Recommendation Report for Works to Tree(s) on trees subject to a Tree Preservation Order (TPO)

REF NO: AW/29/19/T

LOCATION: Moonrakers
Dark Lane
Bognor Regis
PO21 4AJ

PROPOSAL: Reduce north side of 2 No. Macrocapa trees by 3m.

Arun District Council Maps

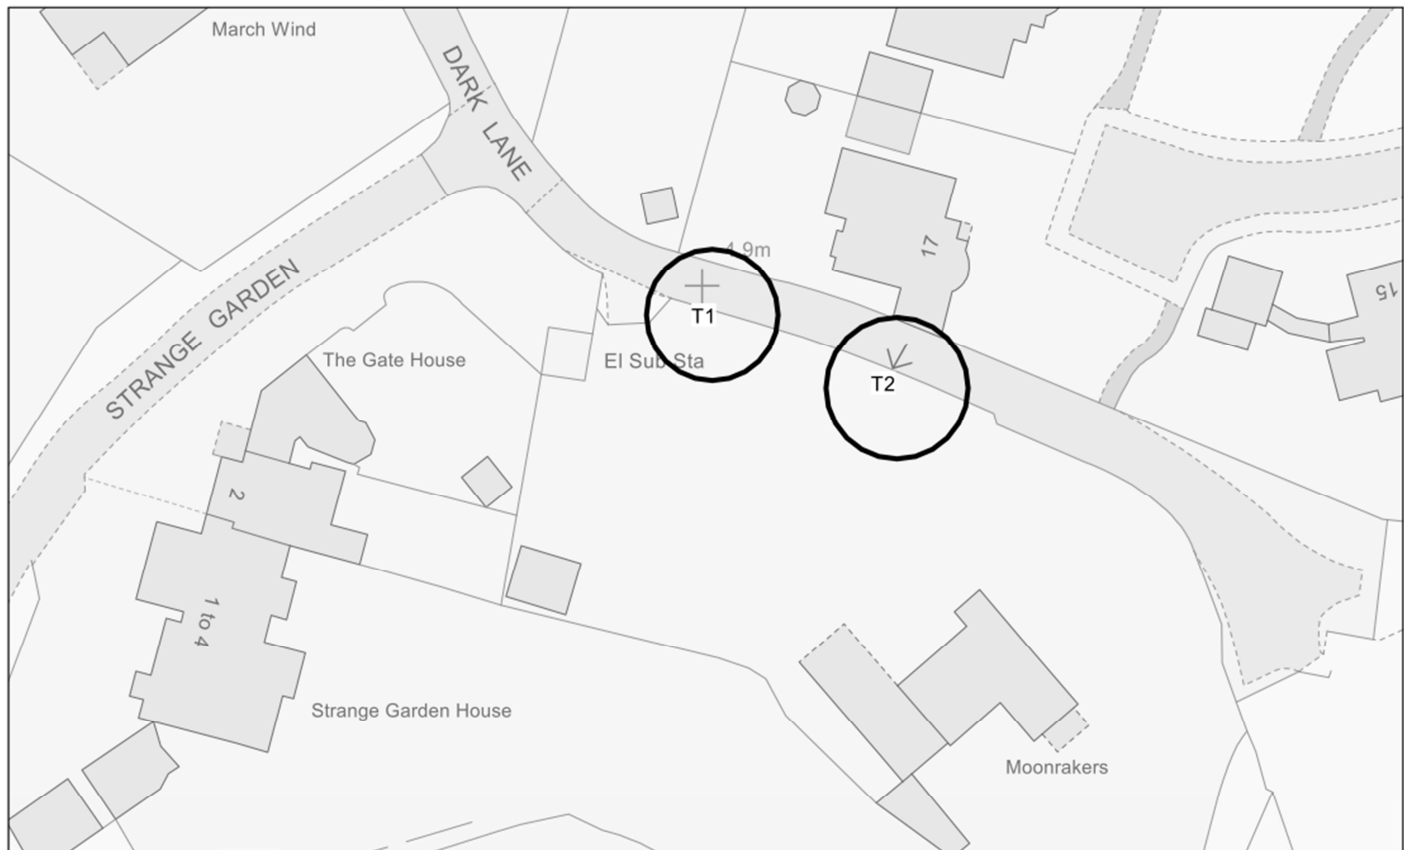
-It is not explicit from the map provided which two trees are the subject of this application. It is for the applicant to ensure that there is no doubt as to which trees are proposed for work; as such there would be grounds for refusing consent for this reason alone.

-On this occasion I have assessed the two (of four) trees which are in closest proximity to neighbouring dwelling (17 Shorecroft) and which I identify on the following plan as most likely candidates for T1 and T2.

-The work proposed is unnecessarily severe and in places would result in damaging loss of leaf-bearing volume, leading to individual branch death.

·I recommend REFUSAL for this application.
